## **Representations by Highways England in respect of the proposed Northampton Gateway Strategic Rail Freight Interchange**

These are the Written Representations of Highways England in respect of the application by Roxhill Limited (the Applicant) for a Development Consent Order (DCO) to authorise a Strategic Rail Freight Interchange at Junction 15 of M1 Motorway.

Drawing Title  
**M1 J15 OUTLINE DRAINAGE STRATEGY**

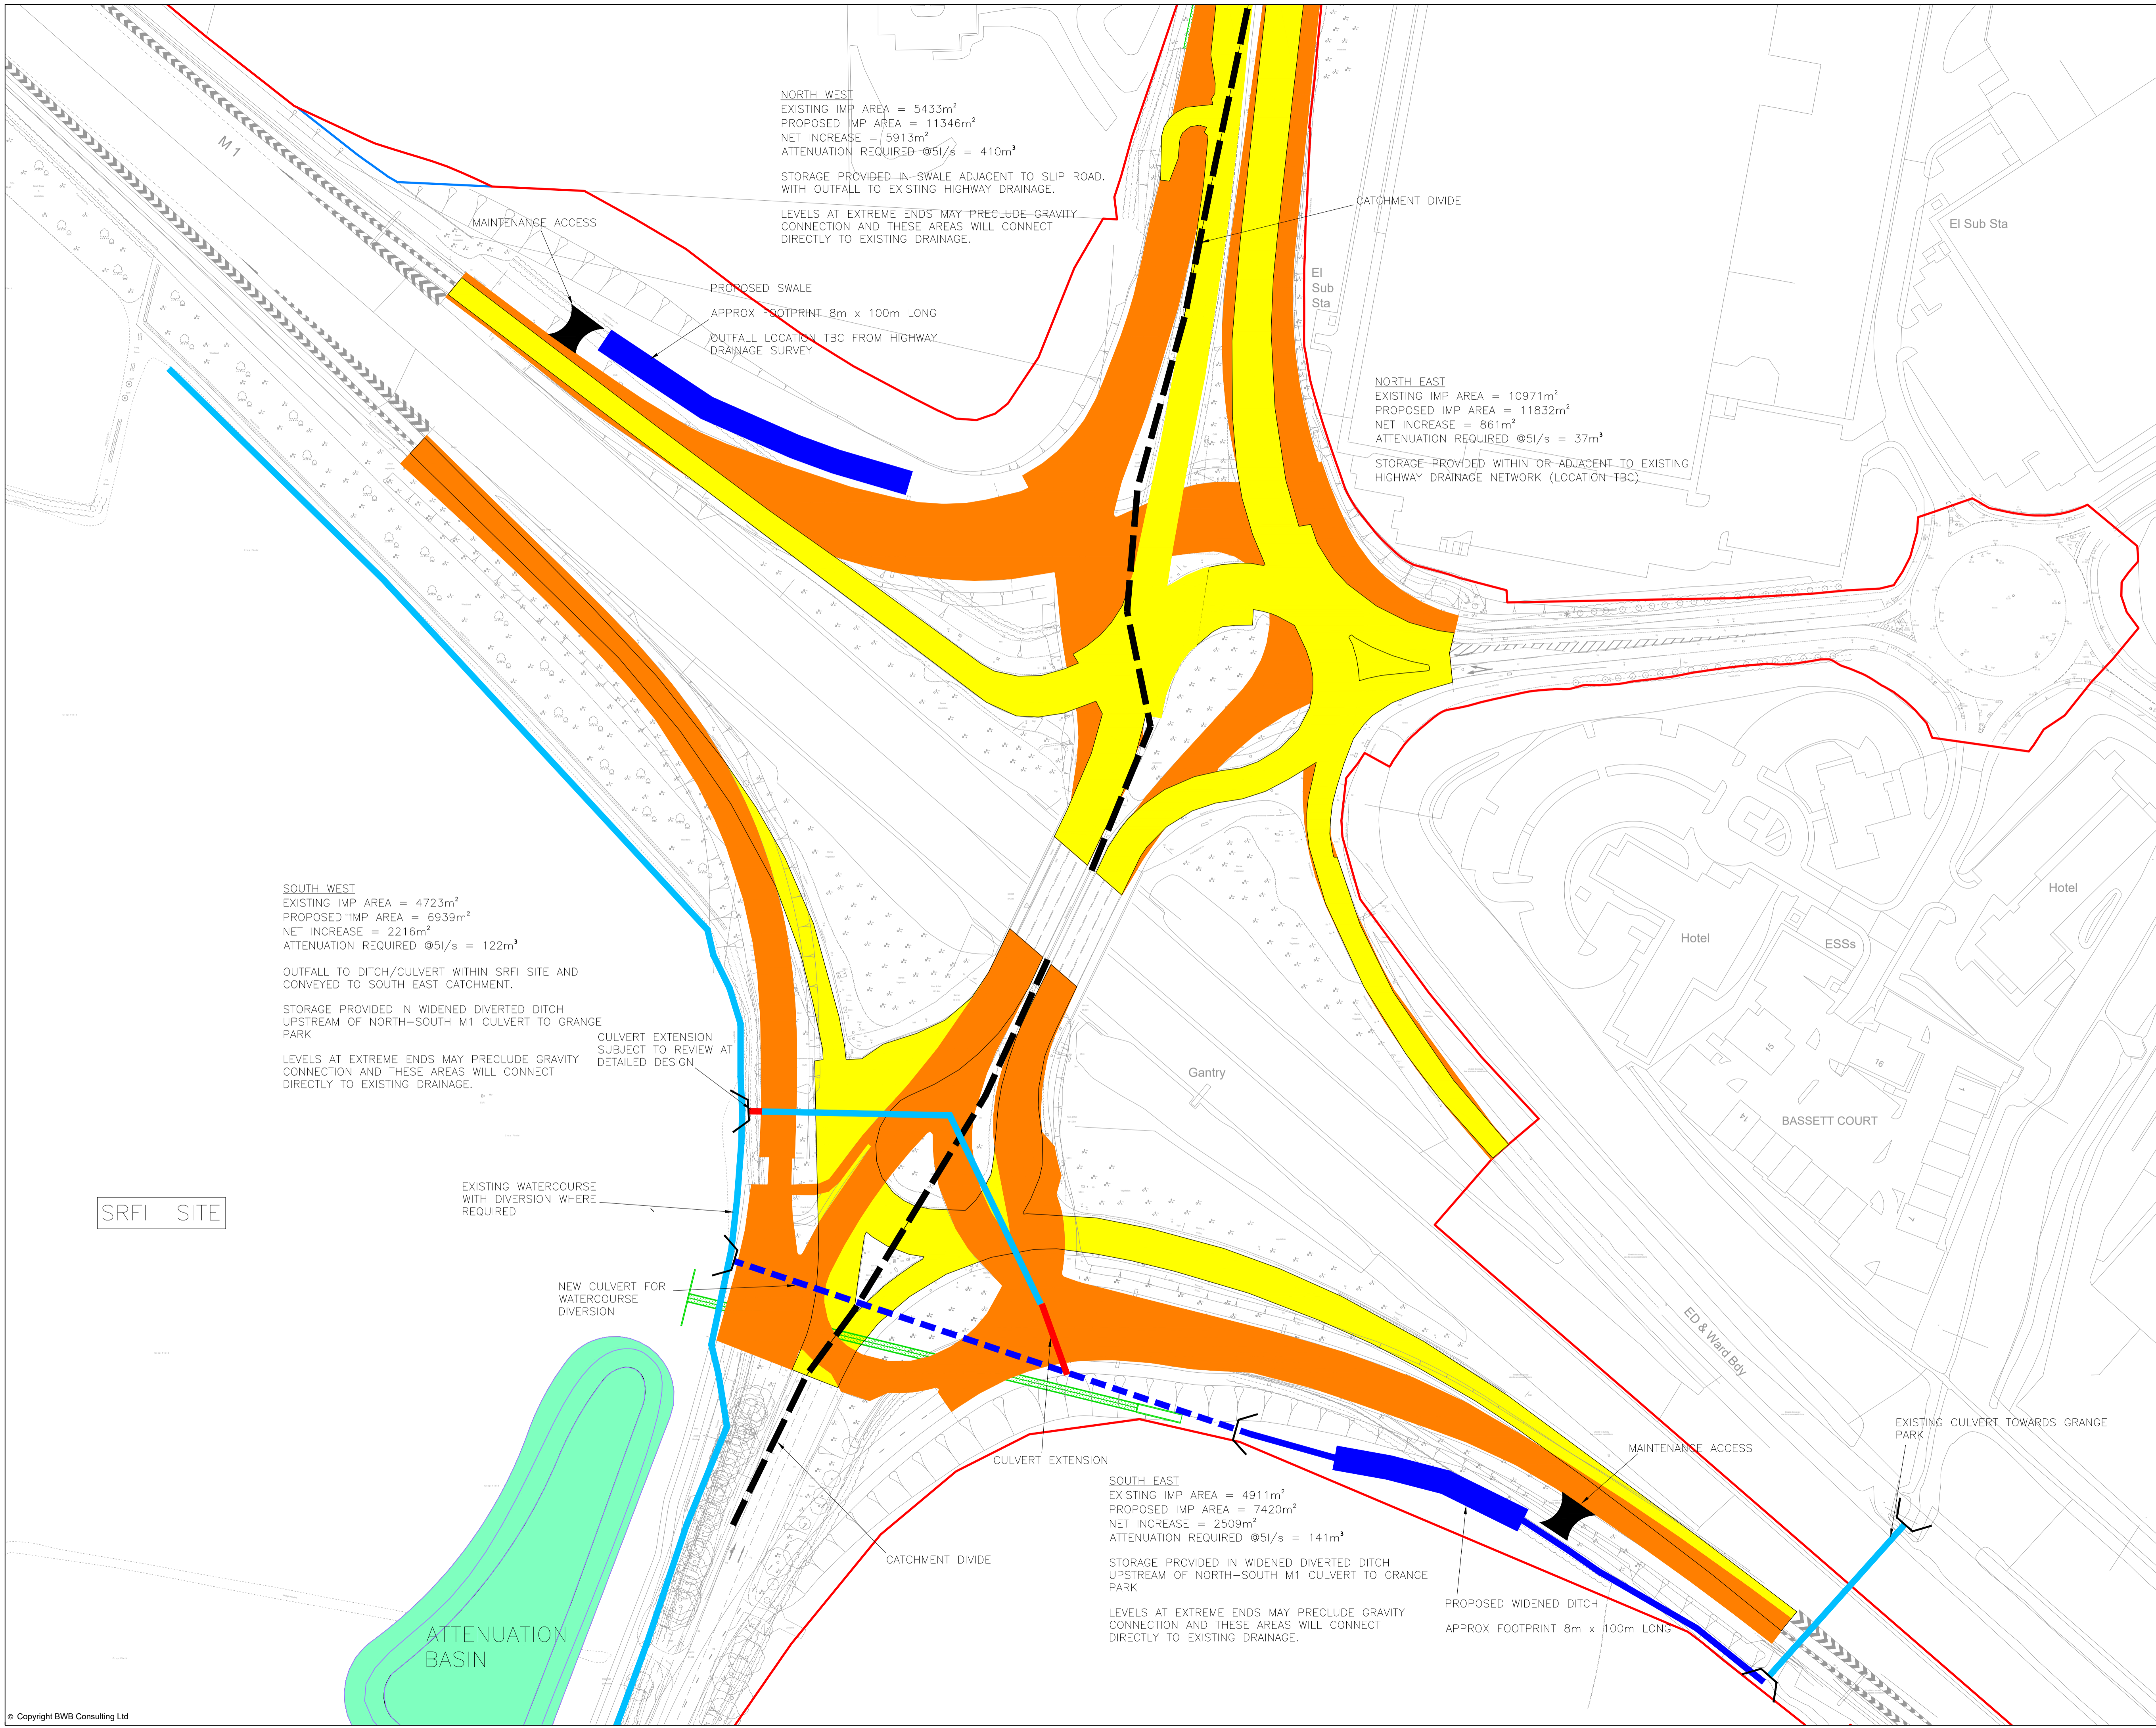
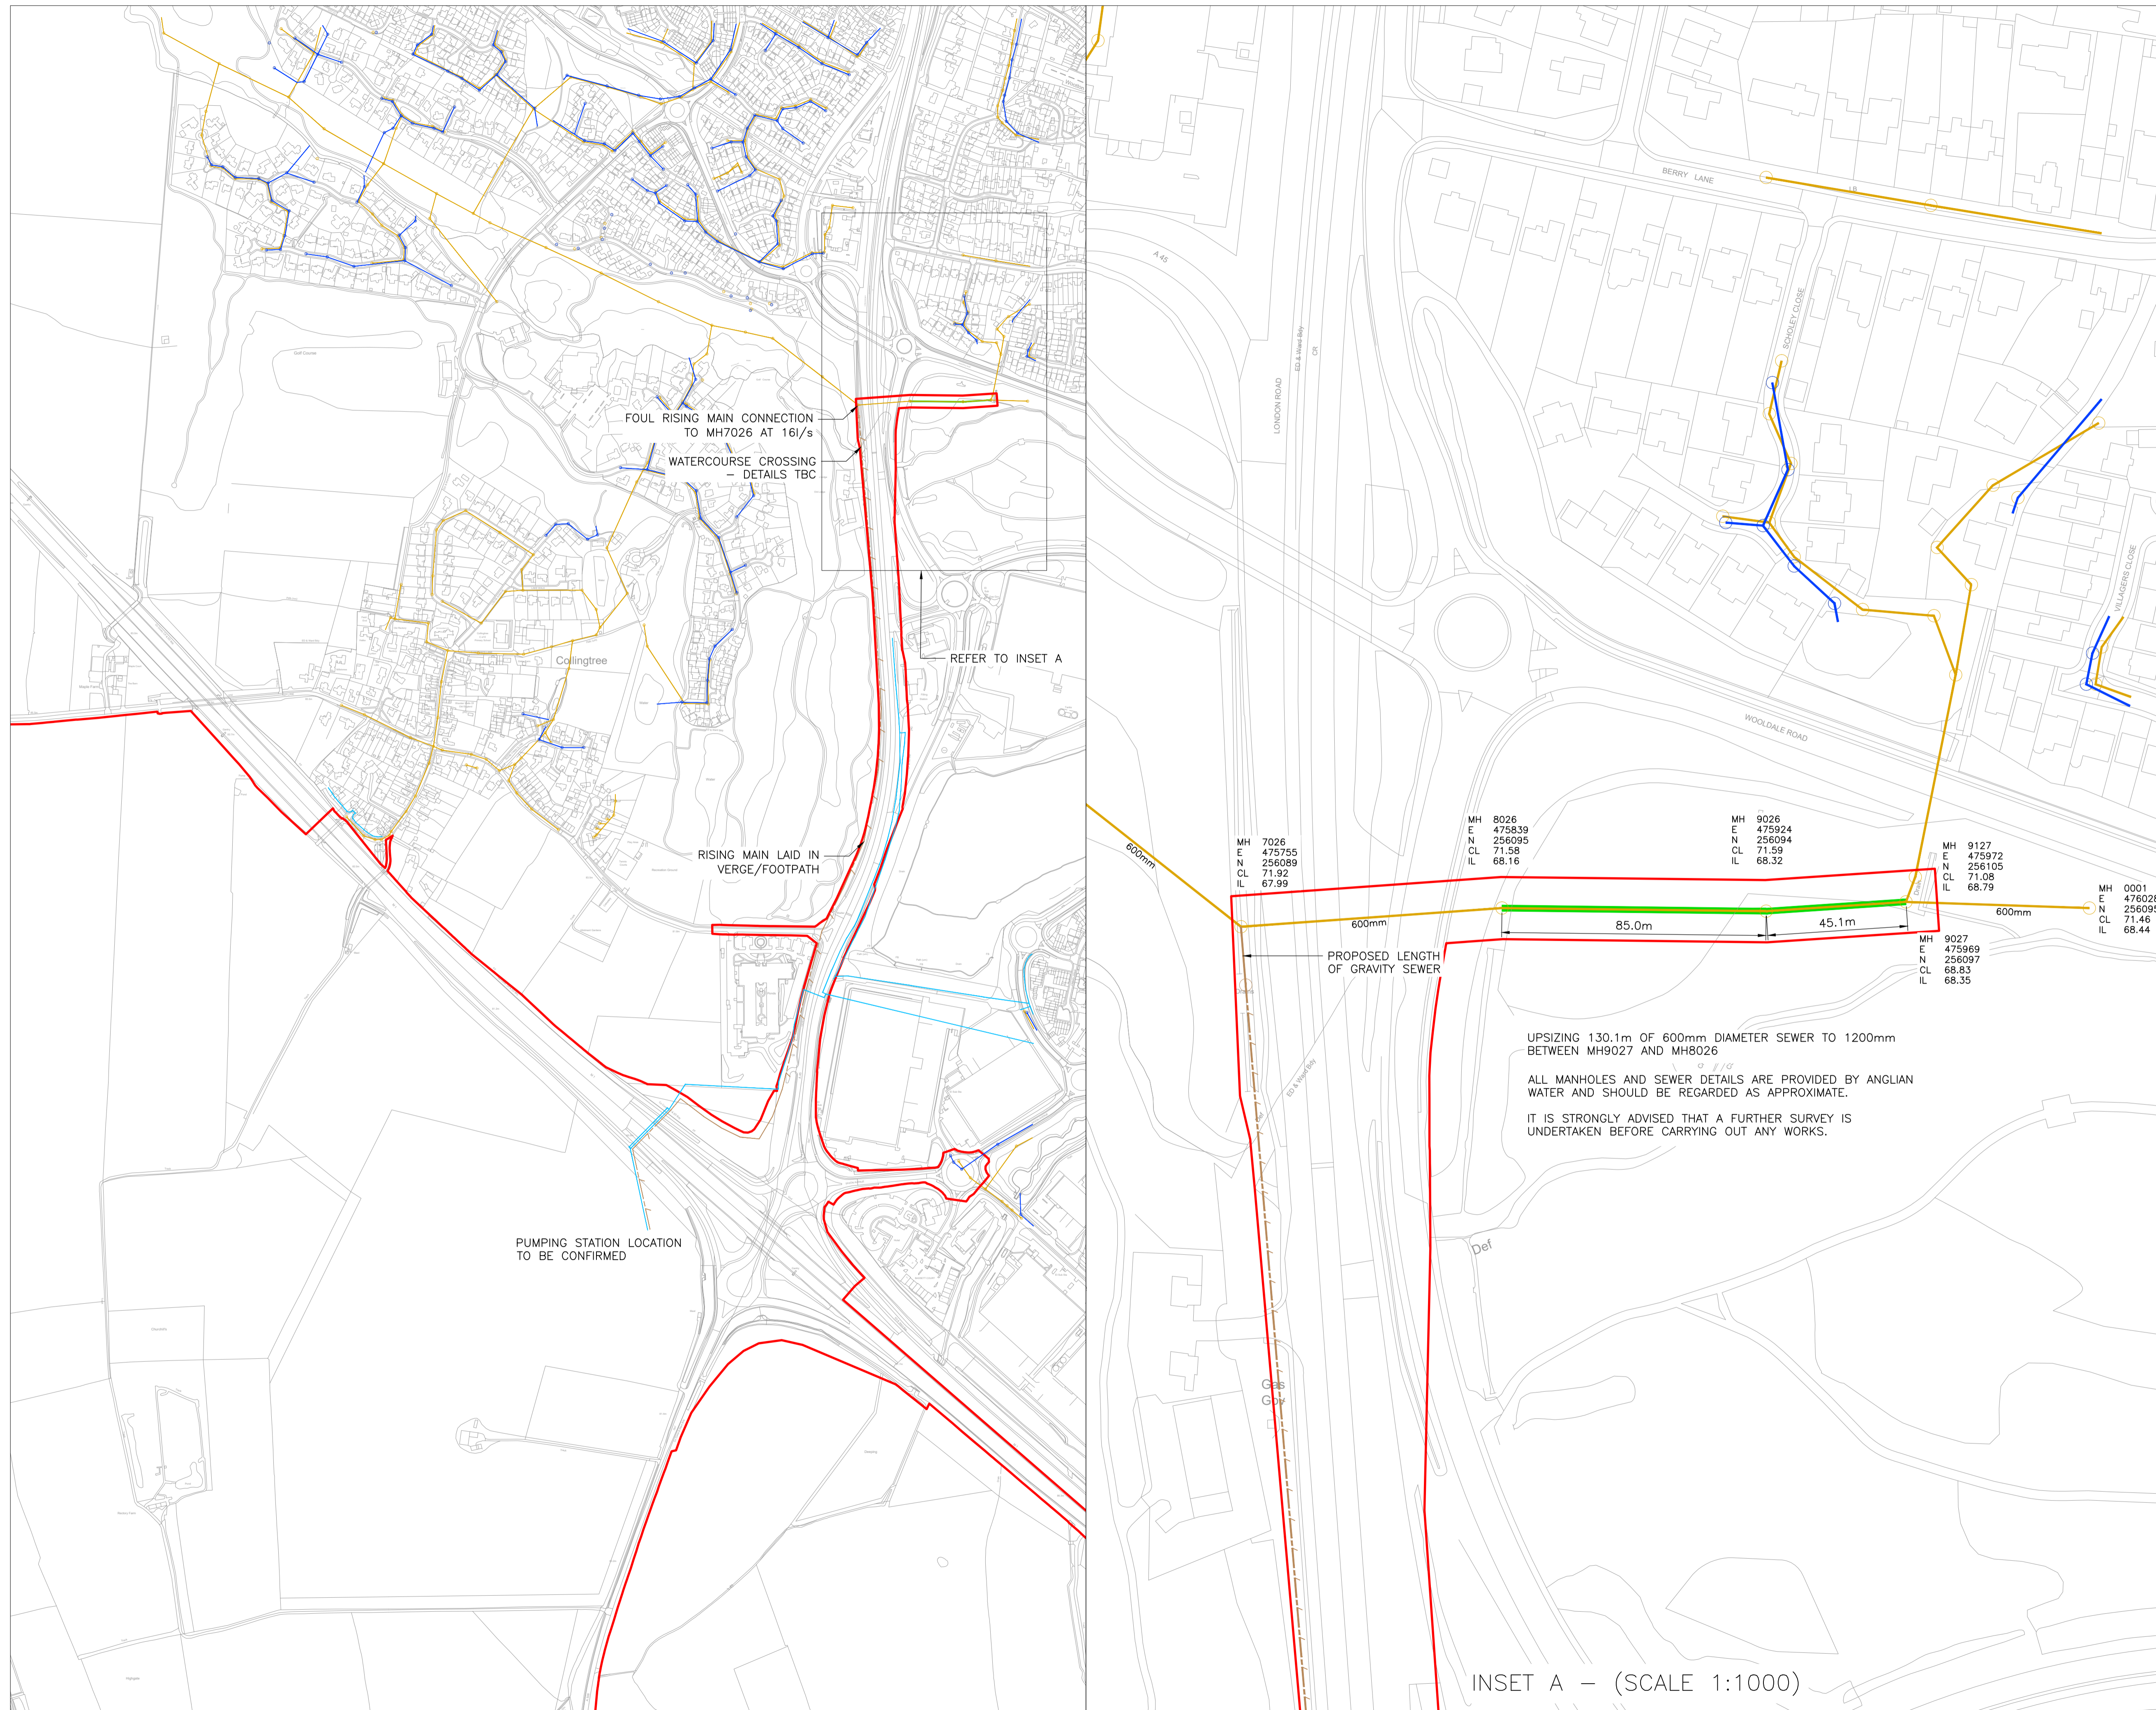
Specialists in Highways England's drainage team have reviewed the undertaker's Sustainable Drainage Statement. Highways England's has two main areas of concern in this regard which relate to the assessment of two of the main outfall locations - 'Collingtree village via 300mm culvert under M1 (to Wootton Brook)' and 'Wootton Brook (via culvert under M1 roundabout)'. The assessments are not considered to be satisfactory, for example there is no clarity of the existing gradient, structural or service condition of the pipes. Highways England requires further information to make an informed decision as to whether or not the proposals are acceptable.

The change of use of the application site will alter the current discharge rate for the site and therefore must be assessed against Dft Circular 02/2013. Based on information available to date Highways England cannot be certain that the undertaker's proposals will be acceptable in accordance with the Circular. We have proposed further work with the undertaker to obtain clarity and resolve this matter and we shall update the Examining Authority in due course.
